79689/APP/2025/2438 - Orbital Industrial Estate, Horton Road - Design Comments

Summary

Broadly acceptable, subject to the following few comments

**TREE SURVEY & CONSTRAINTS PLAN  
IN ACCORDANCE WITH BS 5837:2012**

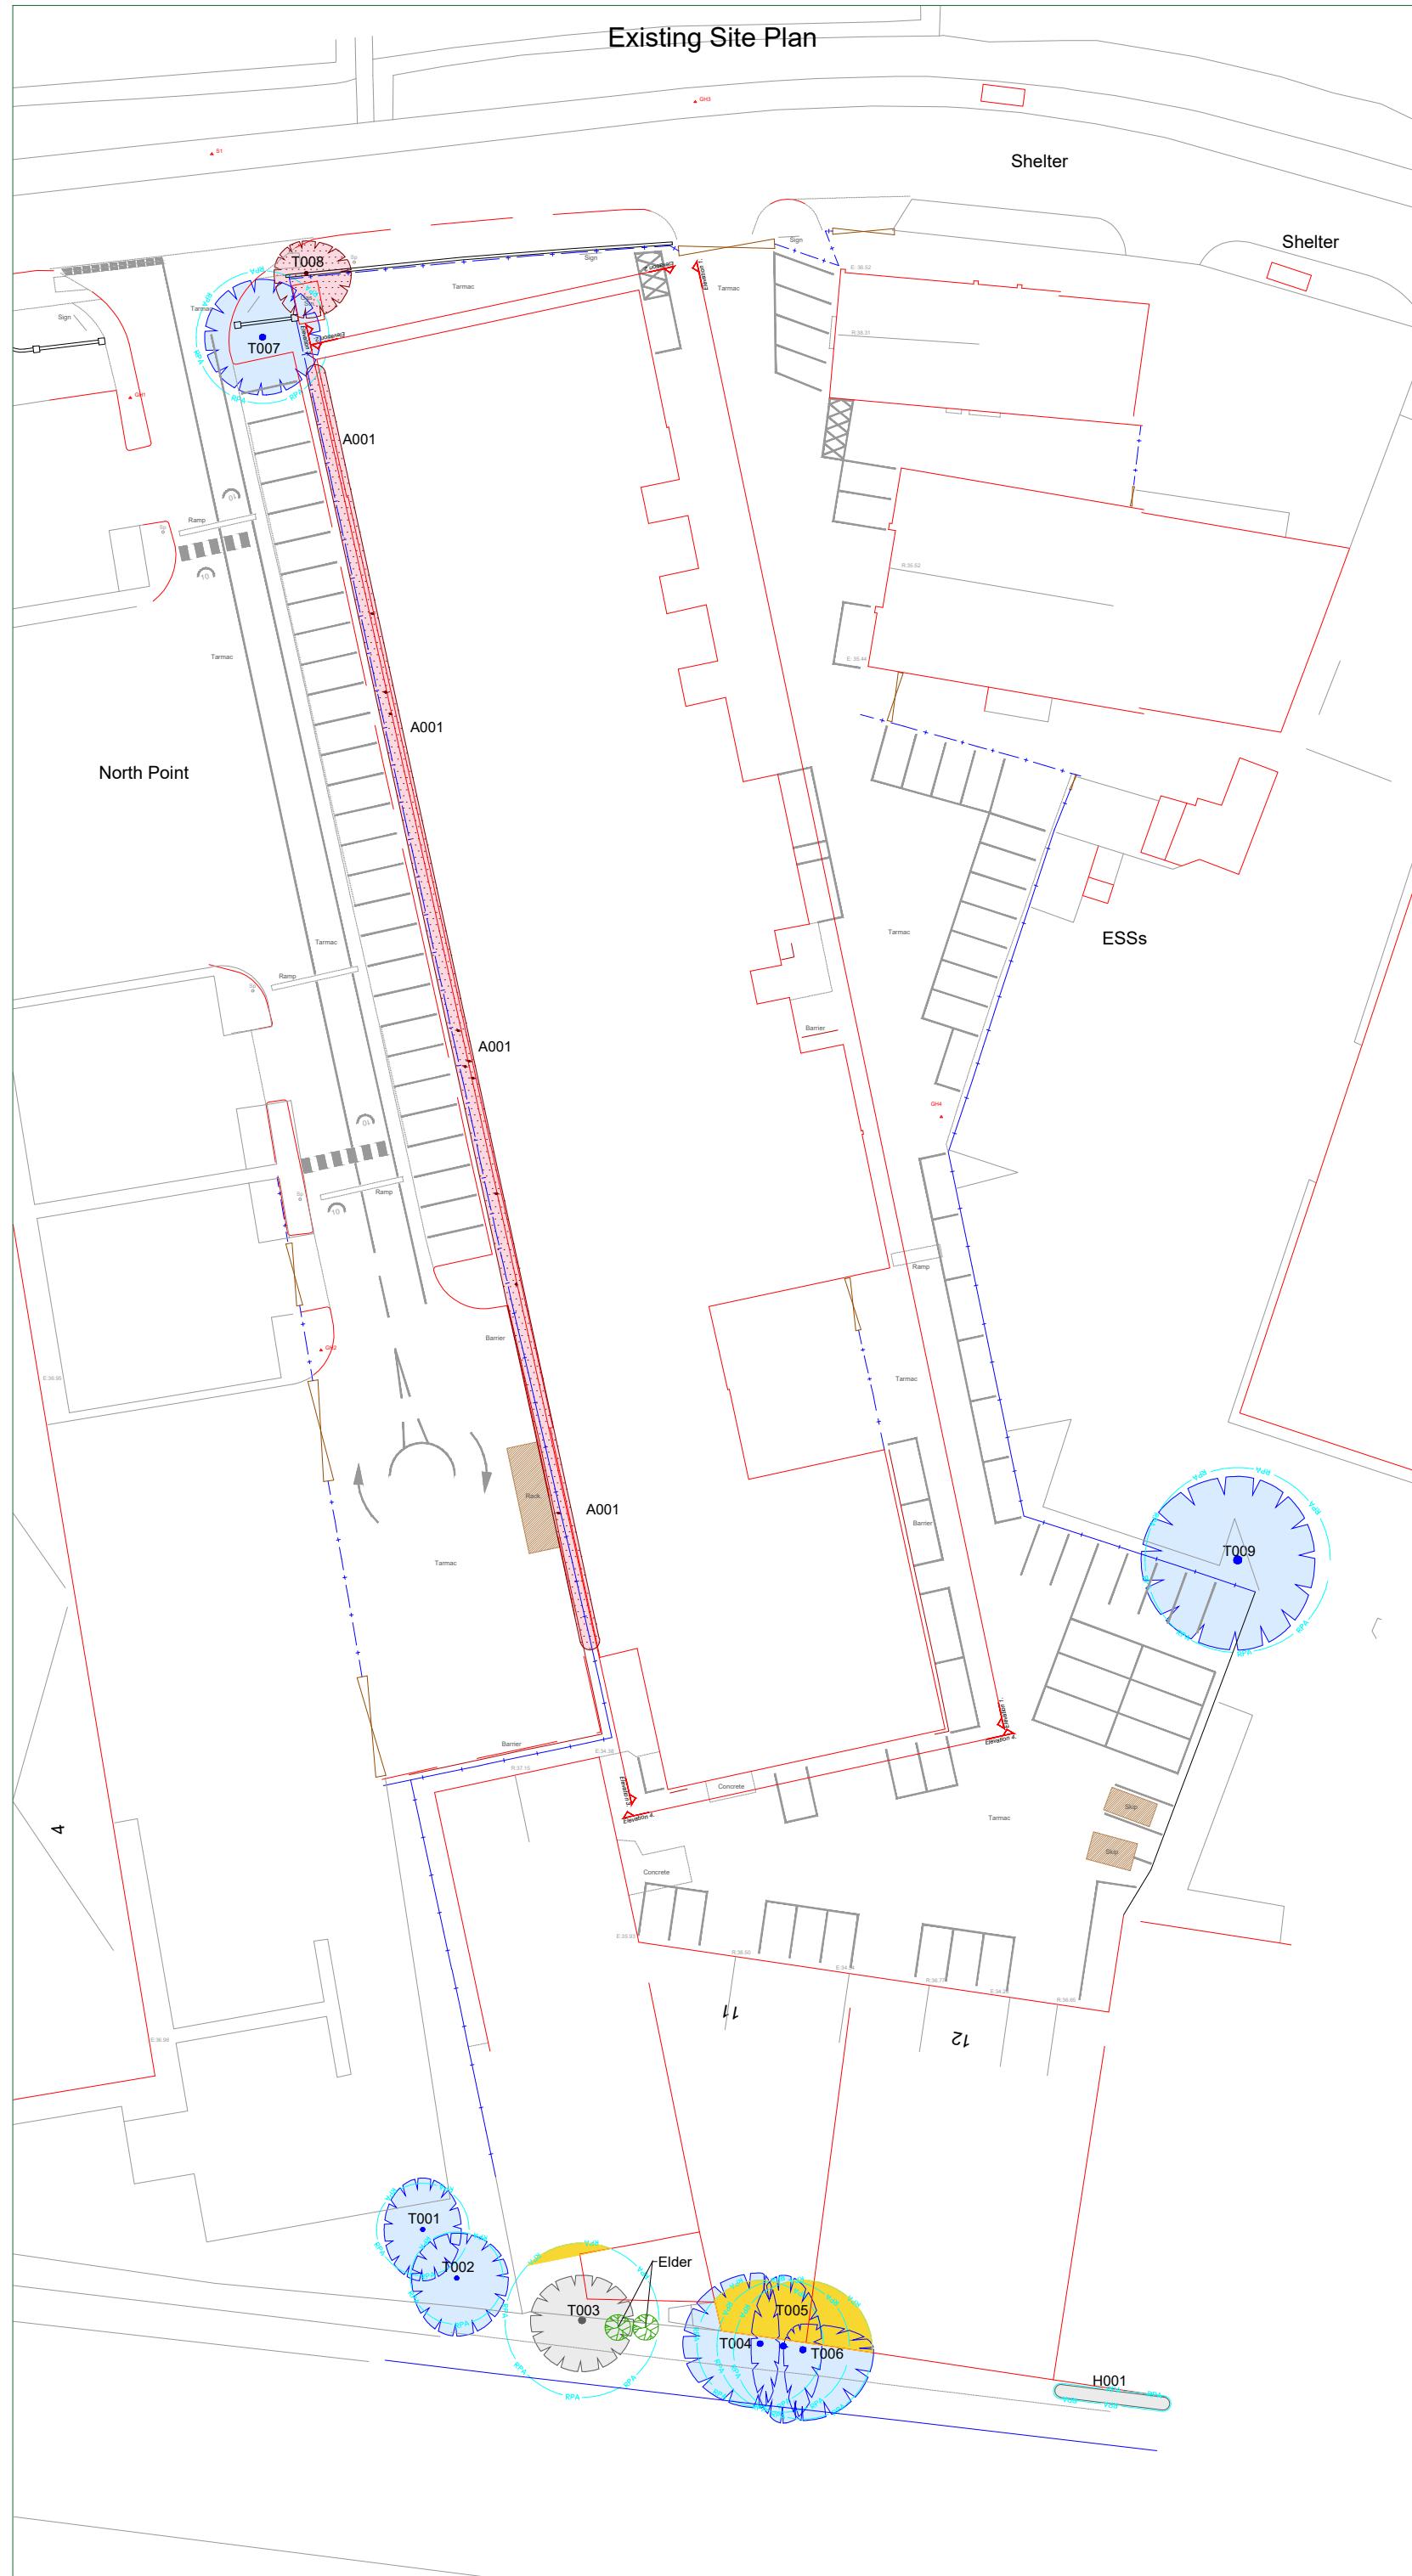
- I. This application is an opportunity to enhance the canal green edge.
- II. Concern is raised that T004, T005 and T006 will be damaged due to the demolition of the existing building. There is also concern the proposed hard surfacing well within the root protection zones will negatively impact these trees. If remains, should be mitigated via construction management (?)
